Re: West Mesa HS Parking Lot Traffic Circulation Layout

This letter is in response to the comments dated March 25, 2010 for the West Mesa High School Parking Lot Grading and Drainage Plan with the engineer's stamp dated 03-03-10 (J10-D005). The comments and the responses are shown below:

SHEET NO:
C-106

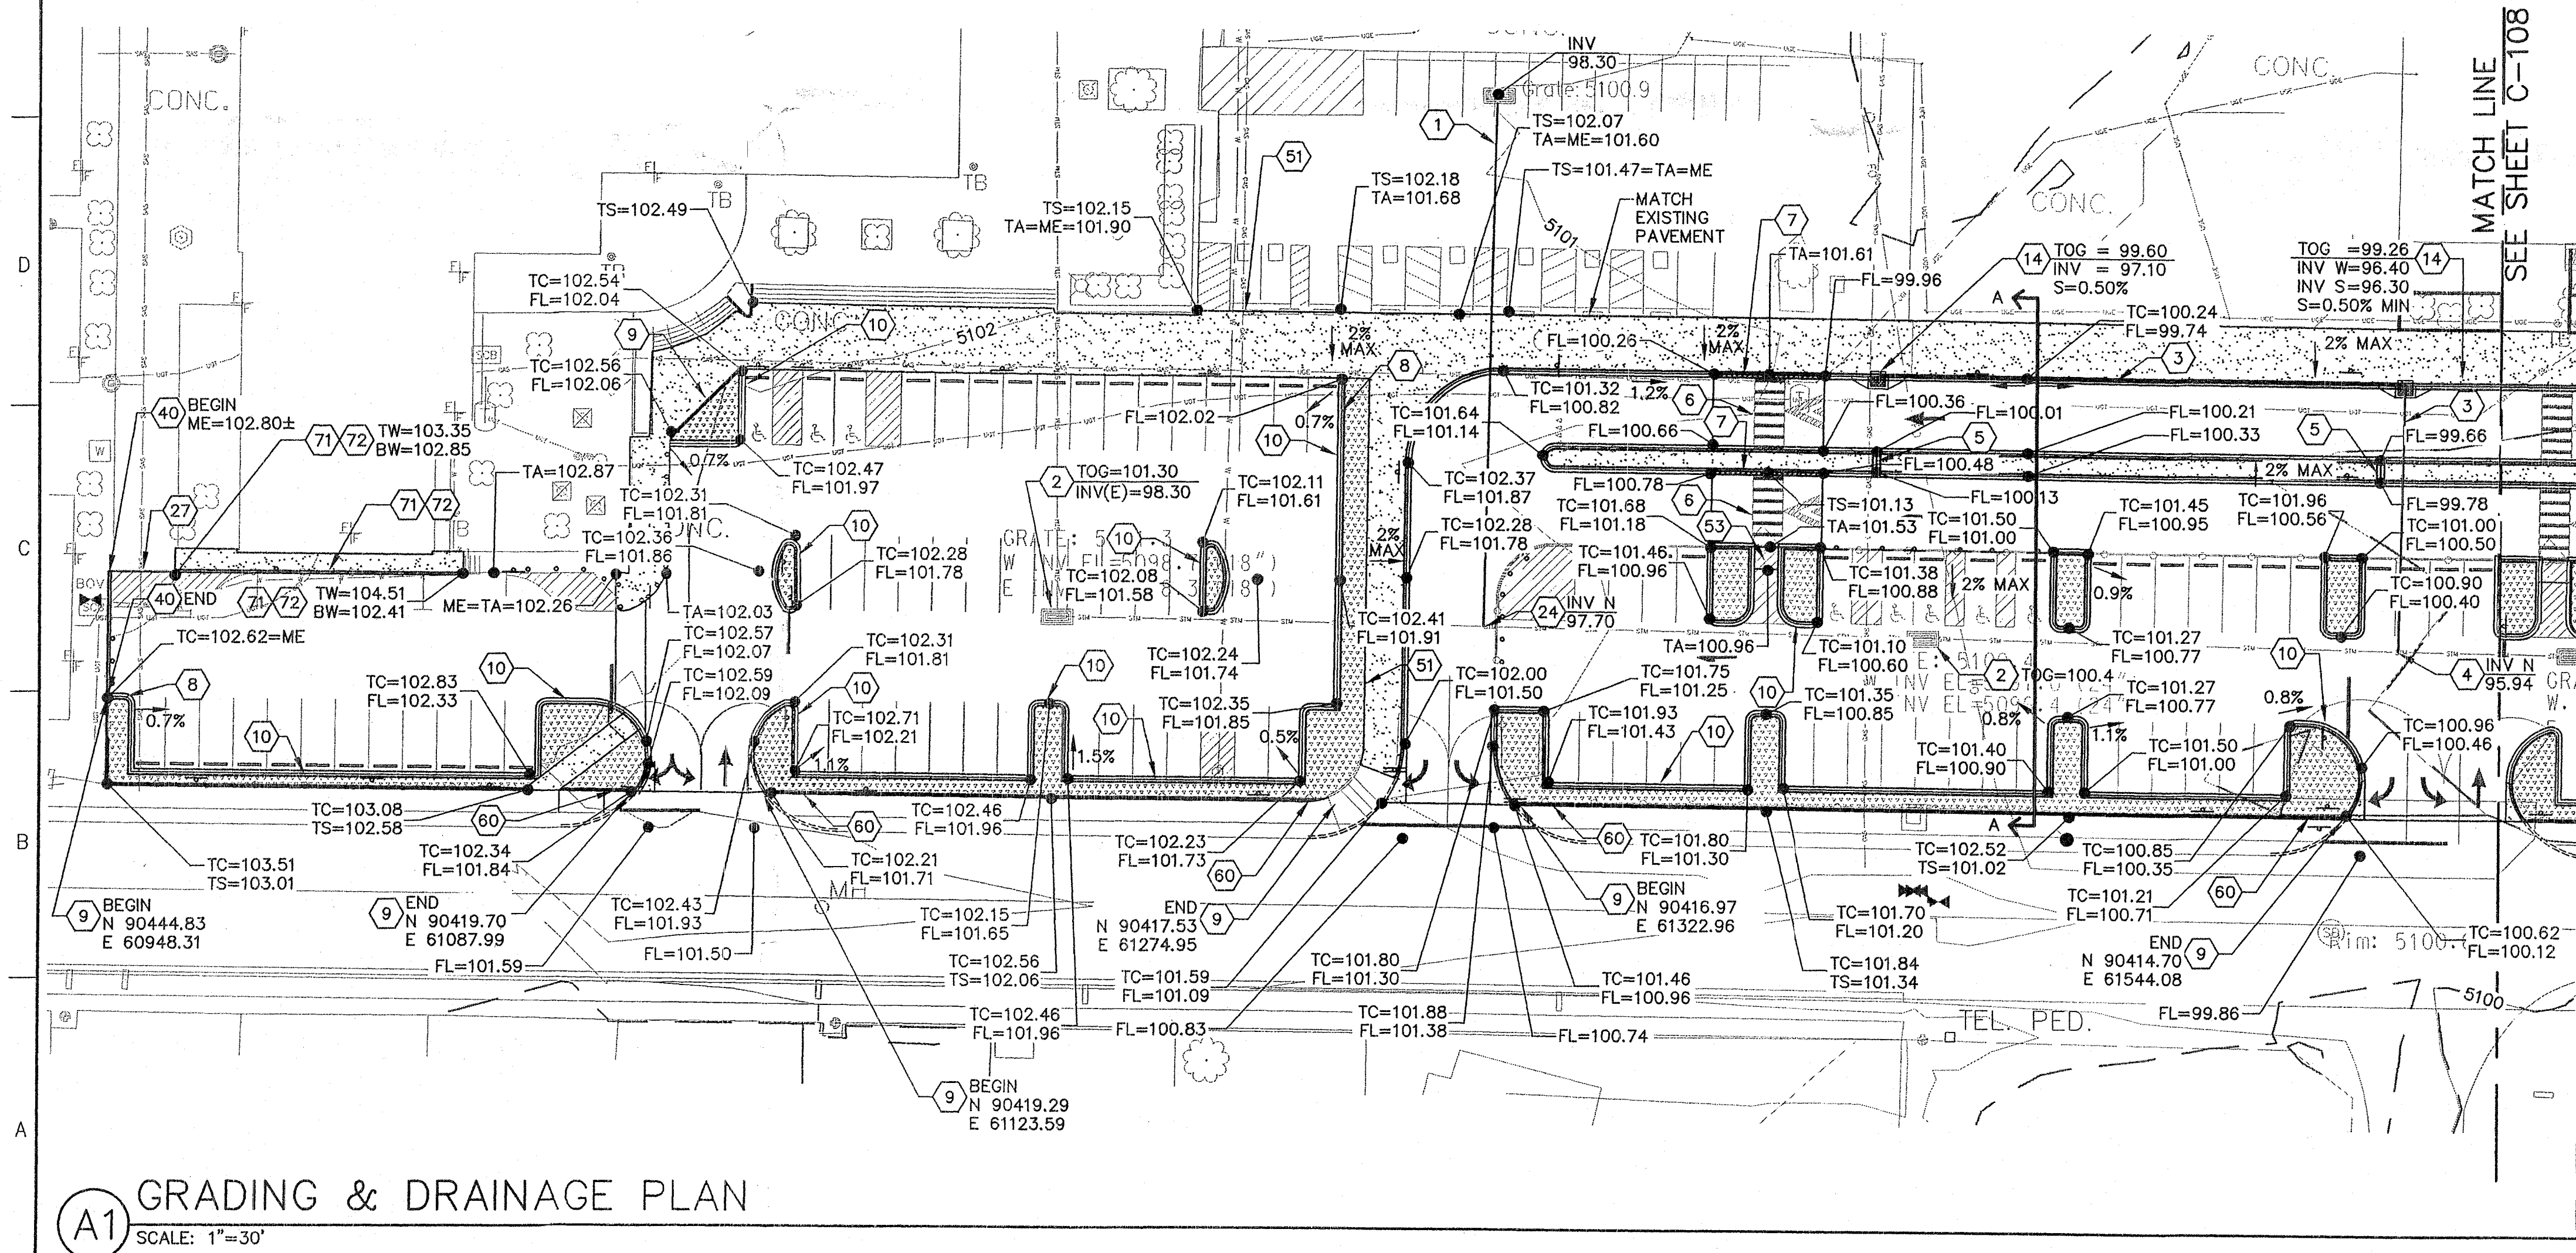
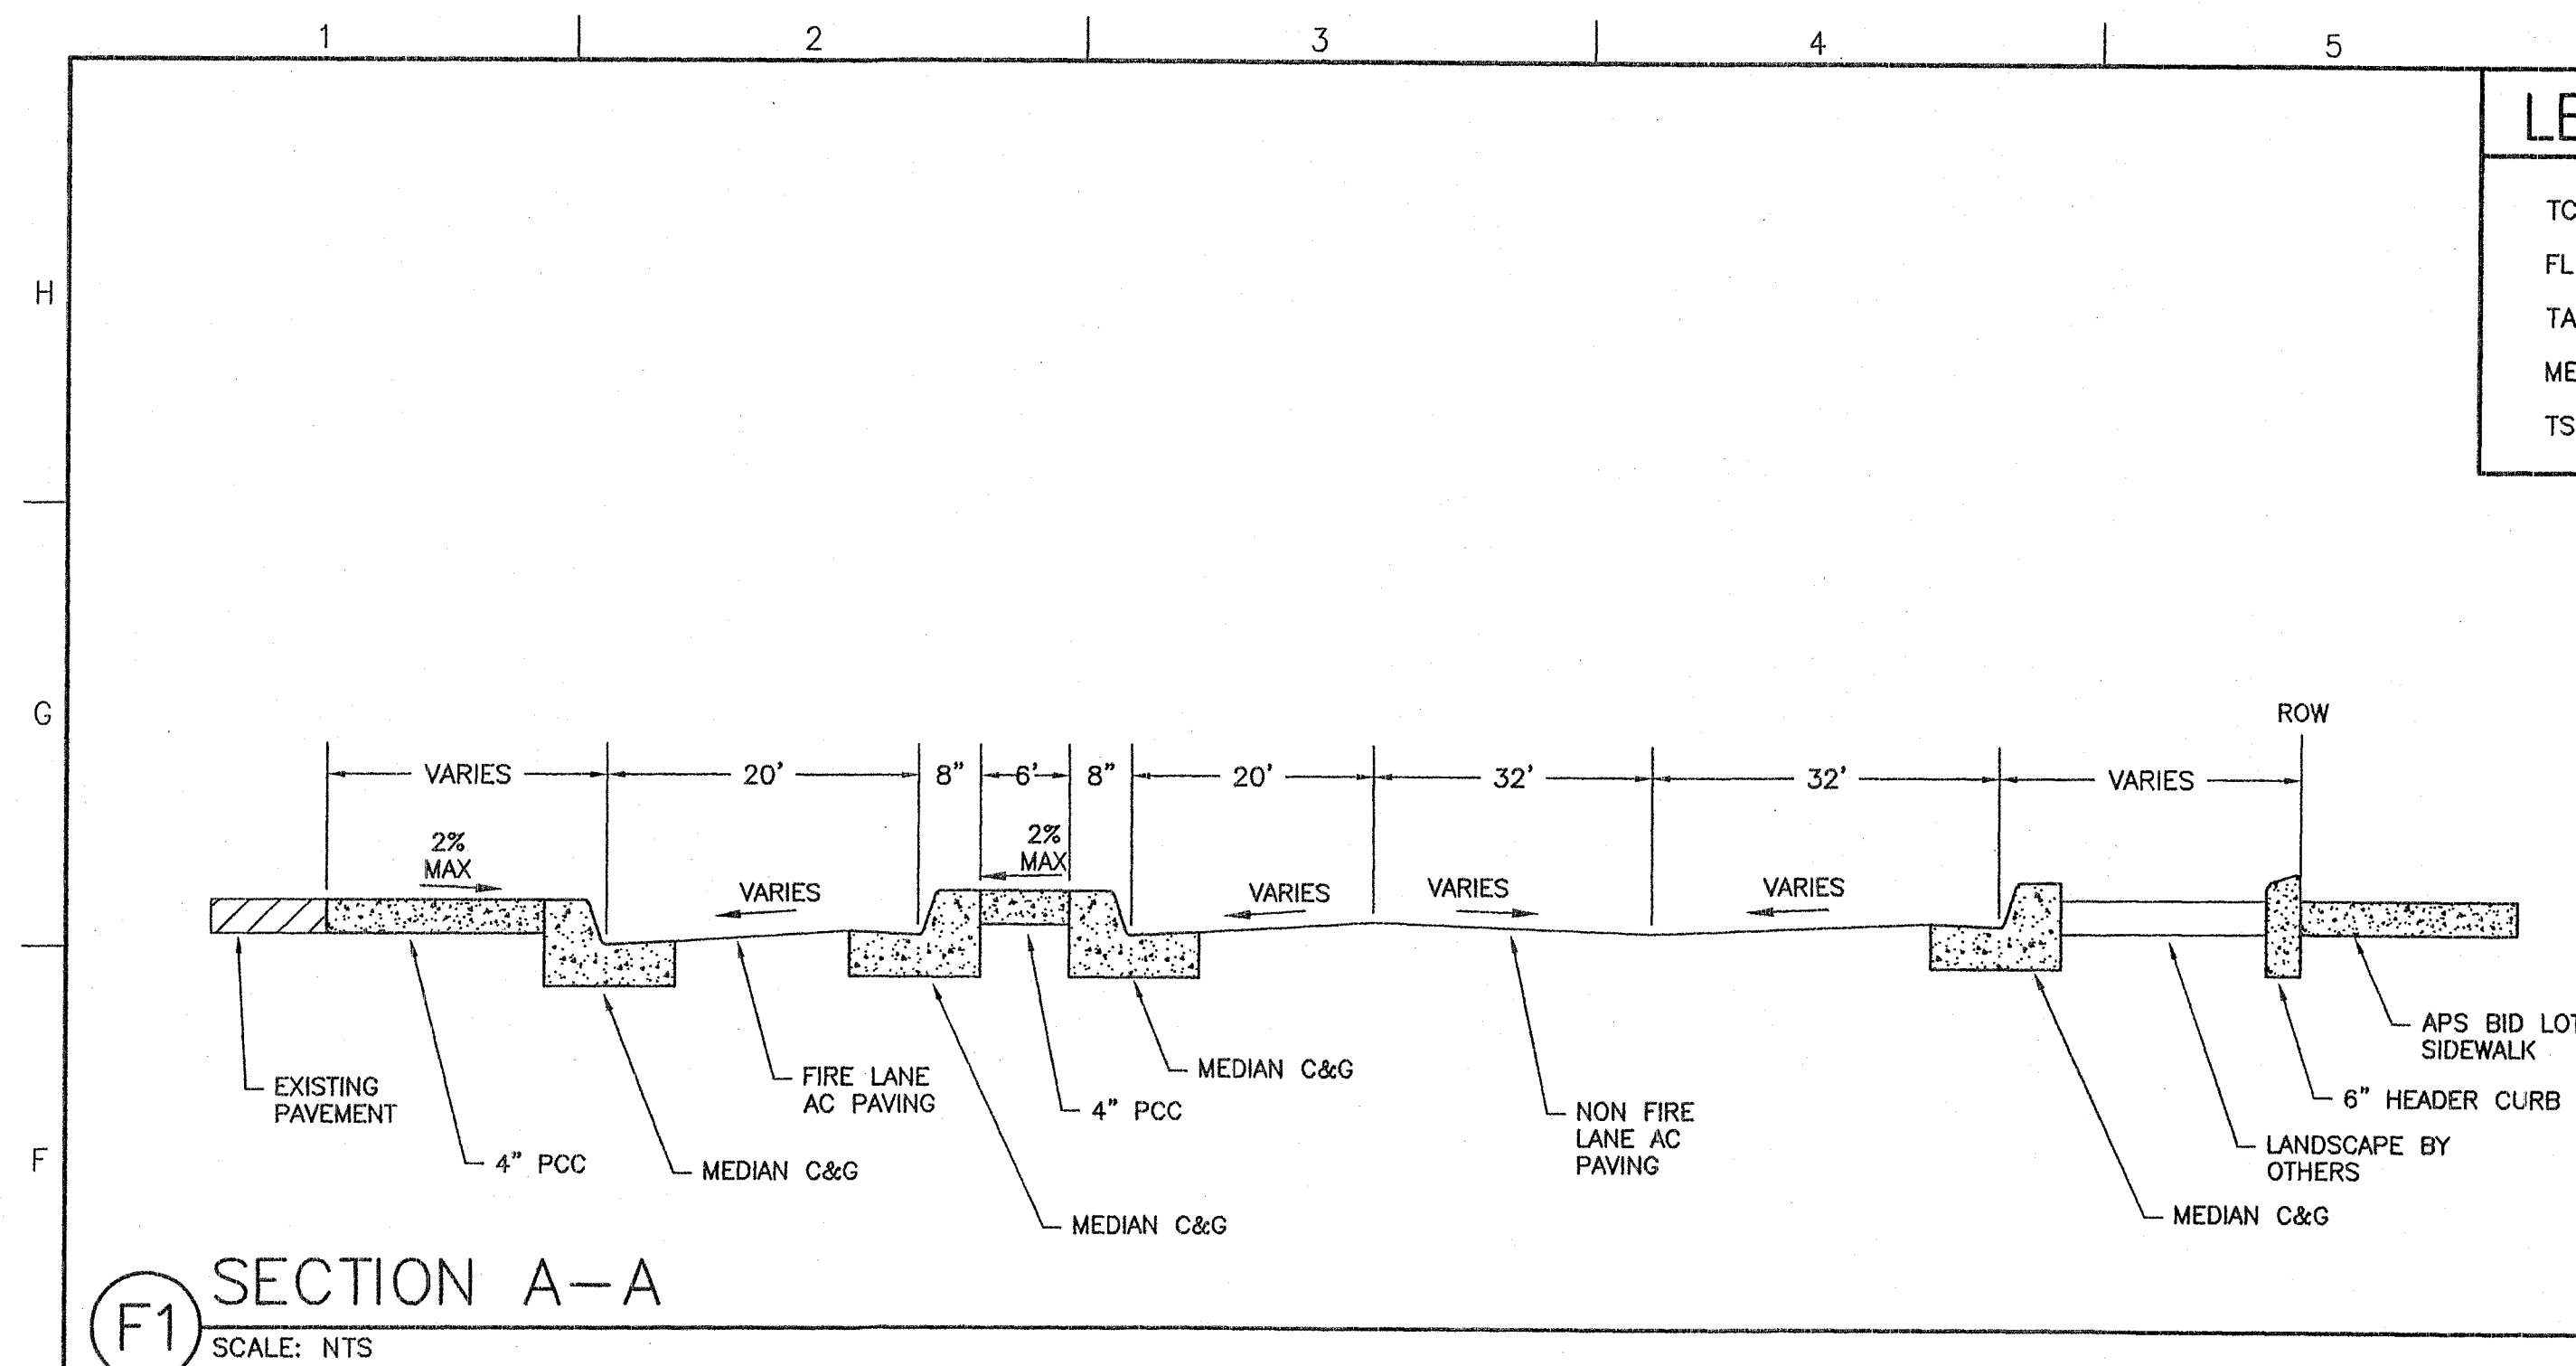
Comment 4: "It appears the proposed median curb on the west end of the project may block flows from the west. Provide elevation data west of this curb and a top of curb elevation."

Response: The curb was blocking the flows from heading west. The median curb was removed and a proposed cut off wall is shown that matches existing grades to let the flows pass east into the parking lot.

The revised grading and drainage plan sheets C-106, C-107 and C-107 are attached for your review.

C-107

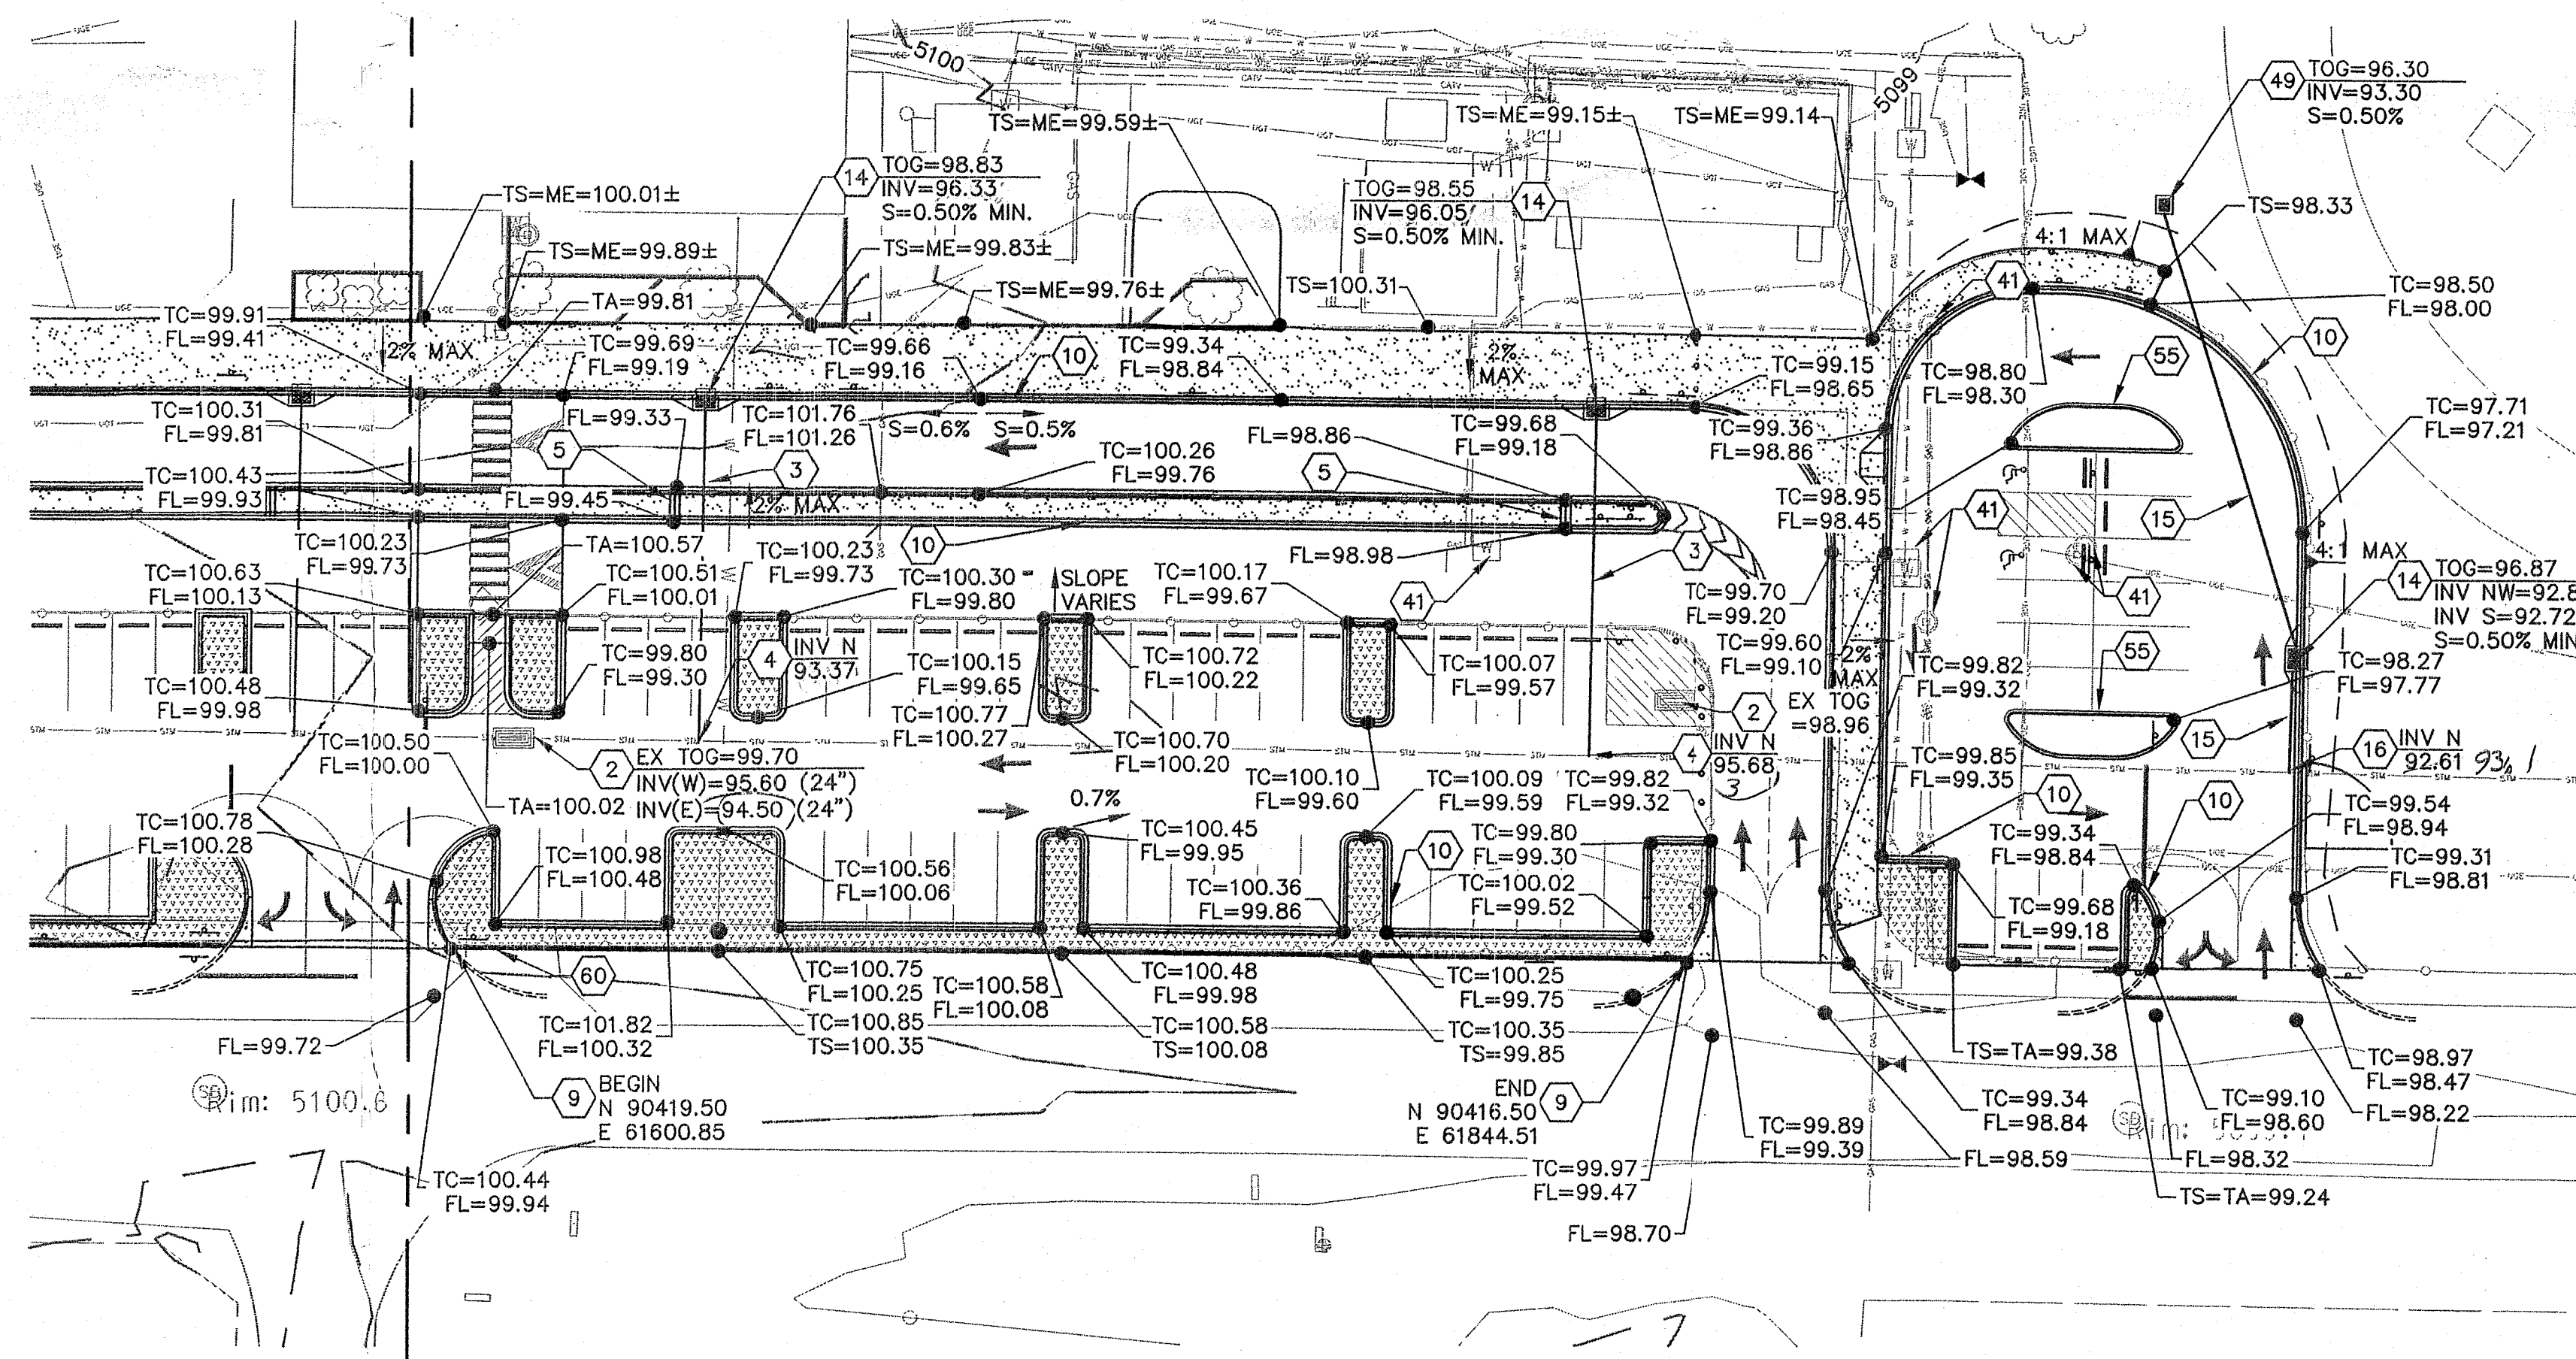
Comment 1: "Provide inverts for the connections to the existing storm drain."

Comment 2: "Provide flow line elevation in Fortuna at the drive entrances."

Comment 3: "Provide existing elevation data (contours or spots)."

Response: Inverts are shown on C-107 and C-108.

Response: The flow line elevations are shown on C-107 and C-108.

Response: The contour elevations are shown on C-107 and C-108.
